Historic England

**REPRESENTATIONS OF THE HISTORIC BUILDINGS AND MONUMENTS
COMMISSION FOR ENGLAND (HISTORIC ENGLAND)**

**APPLICATION BY THURROCK POWER FOR AN ORDER GRANTING
DEVELOPMENT CONSENT FOR THE PROPOSED THURROCK FLEXIBLE
GENERATION PLANT**

APPLICATION REF: EN010092

Project Ref: C:\Users\nikki.coak\OneDrive - RPS Group PLC\Desktop\HER - Thurrock Flexible Energy ES\GISMXD\Figure 2 Viewpoints.mxd

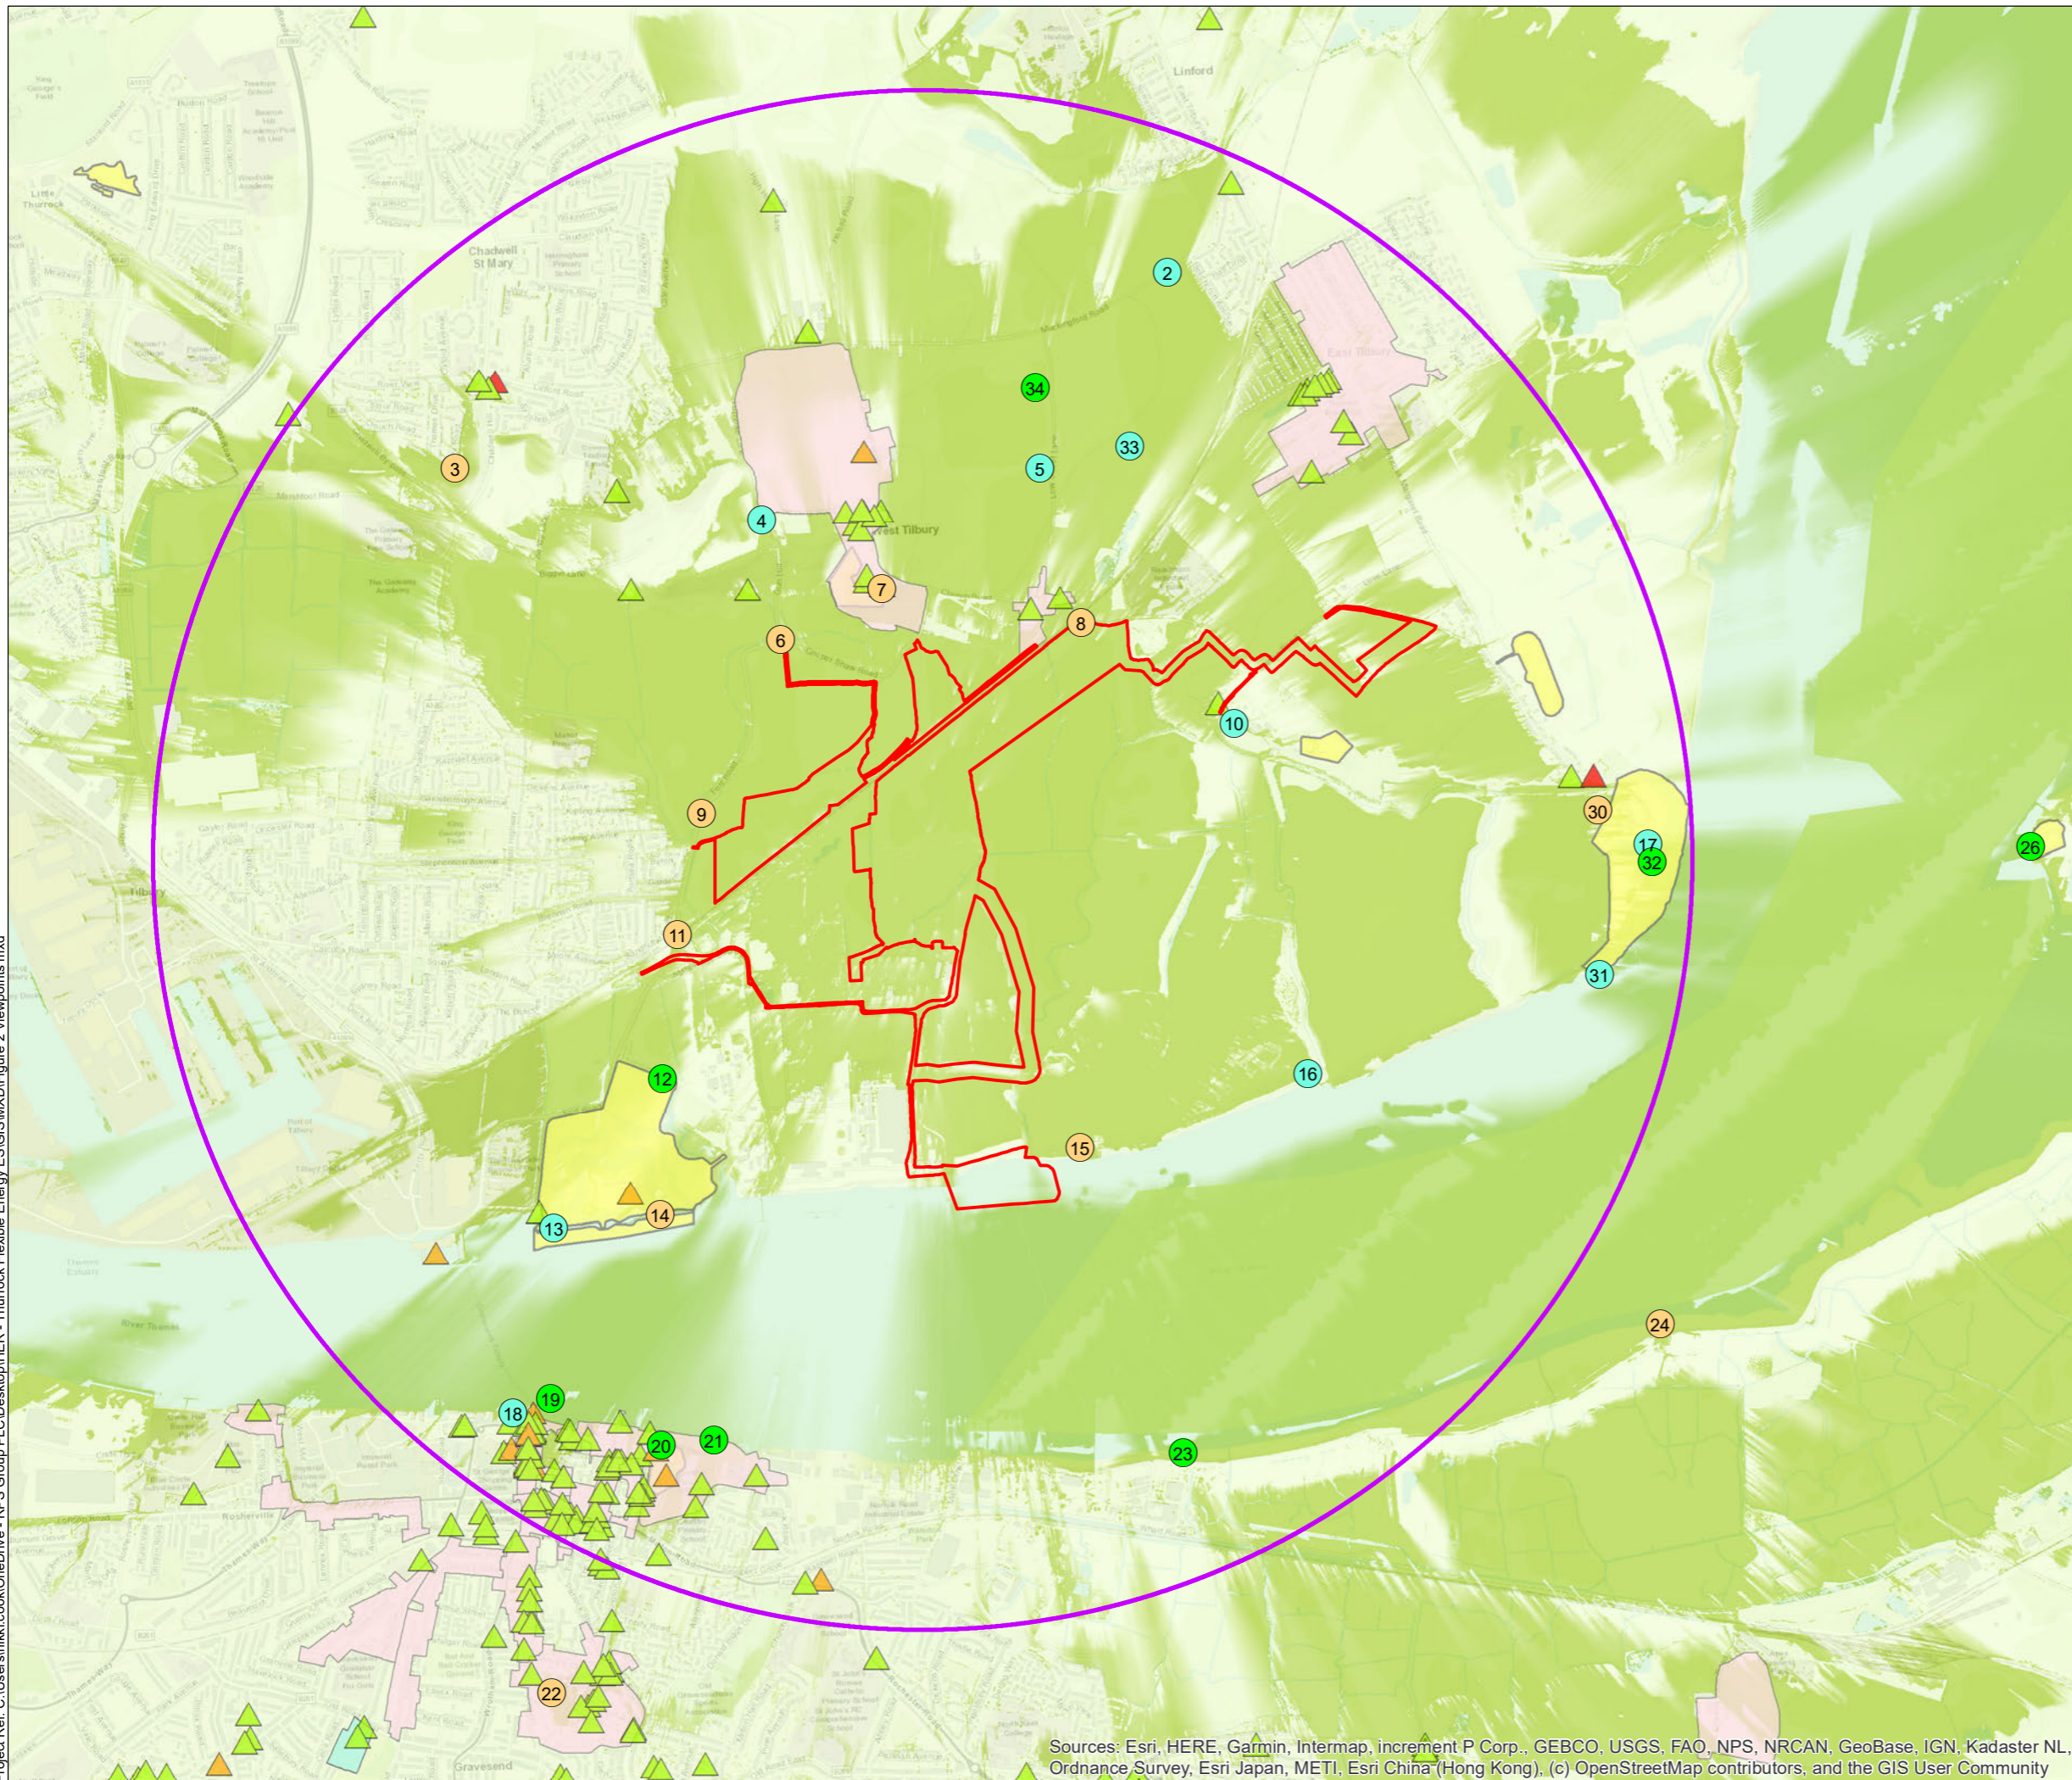
- 5.20 Vol. 3 Chap. 6, Fig. 2.3-4 (see also Procedural Deadline C – further information, Historic Environment Settings Analysis, Nov 2020, Fig. 2) shows the key viewpoints selected in the ES to assess the impact of the proposed development in the landscape. These are all within the zone of theoretical visibility (Vol. 3 Chap. 6, Fig. 2.2). In terms of these key viewpoints, we believe the following eight viewpoints are applicable to designated heritage assets and visualisations – both photowirelines and photomontages, as well as rendered images - should have been prepared for these locations:

- Viewpoints 13-14 for Tilbury Fort, which is a scheduled monument (LEN: 1021092) and the Grade II* Listed Officers Barracks, Tilbury Fort (LEN: 1375568),

- Nos. 17, 30-2 for Coalhouse battery and artillery defences, which is a scheduled monument (LEN: 1013943) and the Grade I Listed Church of St Katherine (LEN: 1337129),

- No. 7 for Earthworks near Church, West Tilbury, a scheduled monument (LEN: 1002199) and the Grade II* Listed Church of St James (LEN: 1111541),

- Nos. 4 and 7 for West Tilbury Conservation Area (Vol. 3 Chap. 6, Fig. 2.3). In addition Viewpoint 8 provides visualisations just to the southeast of Low Street, which is also part of the Conservation Area.

- 5.21 The ES provides photographs (both winter and summer views) from the key viewpoints (with the exception of Bowaters Farm Battery) towards the proposed development. However, the ES provides photowirelines for only four of the eight key viewpoints (7, 14, 30, 32) identified above and photomontages for only three key viewpoints (7, 14, 30), which we believe are applicable to designated heritage assets (ES Vol. 3 Chap. 6, Figs. 4.3, 4.8, 4.18 and 4.19, 4.23, 4.27, 4.31). We note that additional photomontages have been provided for three viewpoints from Tilbury Fort (Procedural Deadline C – further information, Historic Environment Settings Analysis, Nov 2020, Viewpoints 1, 2, 3), although the locations of these have not been plotted on Procedural Deadline C – further information, Historic Environment Settings Analysis, Nov 2020, Fig. 2.
